Subject: 2026/90927 at location adj, 15-17, Windmill Hill Lane, Emley Moor, Huddersfield, HD8 9TA

Please see ecological commentary below:

PROPOSED SITE PLAN

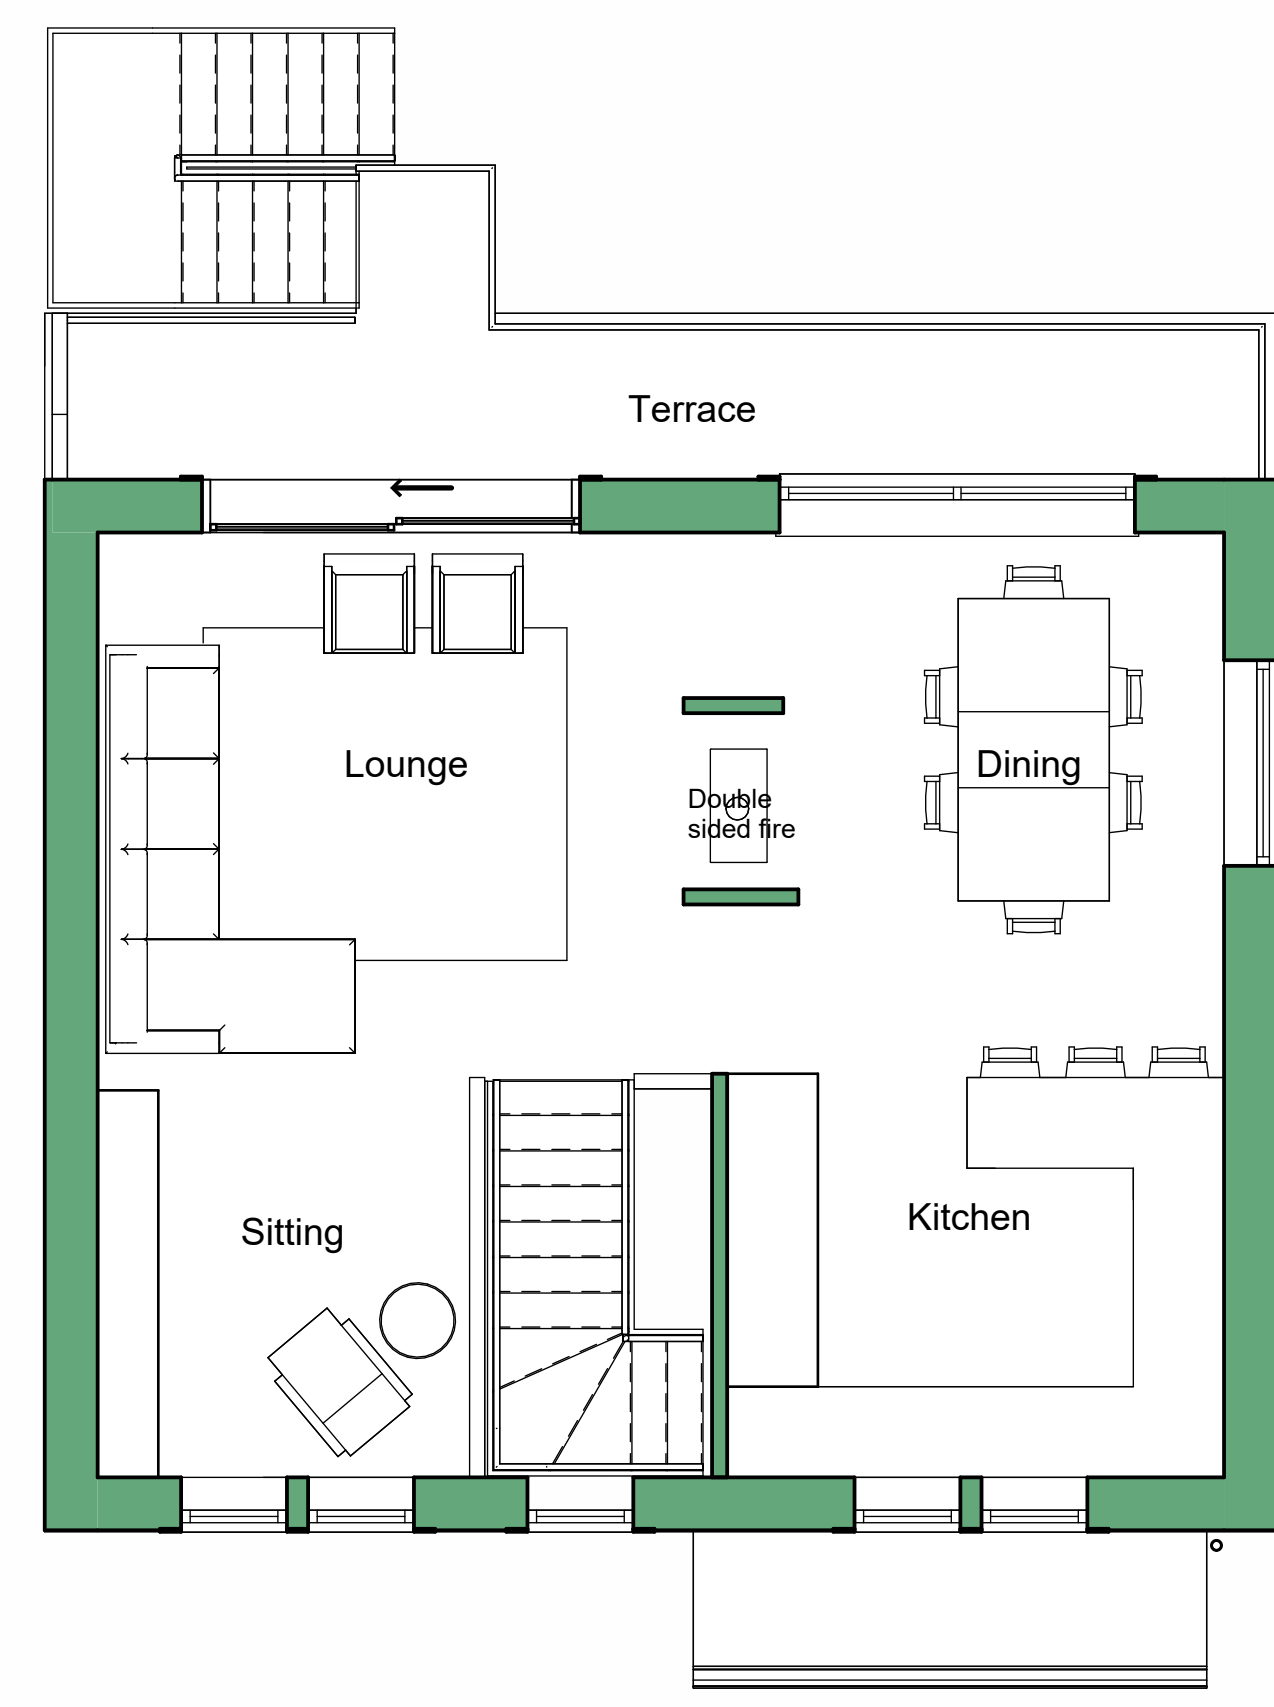
The site consists of grassland, a greenhouse, hardstanding, stone walls, hedgerows, and a line of trees. It does not appear that the hedgerows and trees are to be impacted by the works, but protection measures are recommended. The greenhouse does not appear to be suitable for roosting bats and nesting birds. A PEA does not appear to be warranted.

A Hedgerow and Tree Protection Plan detailing measures for the protection of trees and hedgerows during the works will be submitted to and approved by the LPA prior to the commencement of works on site, including site clearance and delivery of materials.

Hedgerow and tree protection measures will include temporary fencing for the protection of hedgerows in accordance with BS 5837:2012 Trees in relation to design, demolition and construction – Recommendations. Any alternative fencing type or position not in accordance with BS 5837:2012 will be agreed in writing by the LPA prior to the start of development.

The root protection fencing will define the works exclusion zone around hedgerows and trees. Activities liable to be harmful to hedgerows and trees are prohibited within this exclusion zone, unless agreed in writing with the LPA. The approved hedgerow and tree protection measures will remain in place until the completion of development or unless otherwise agreed in writing with the LPA.
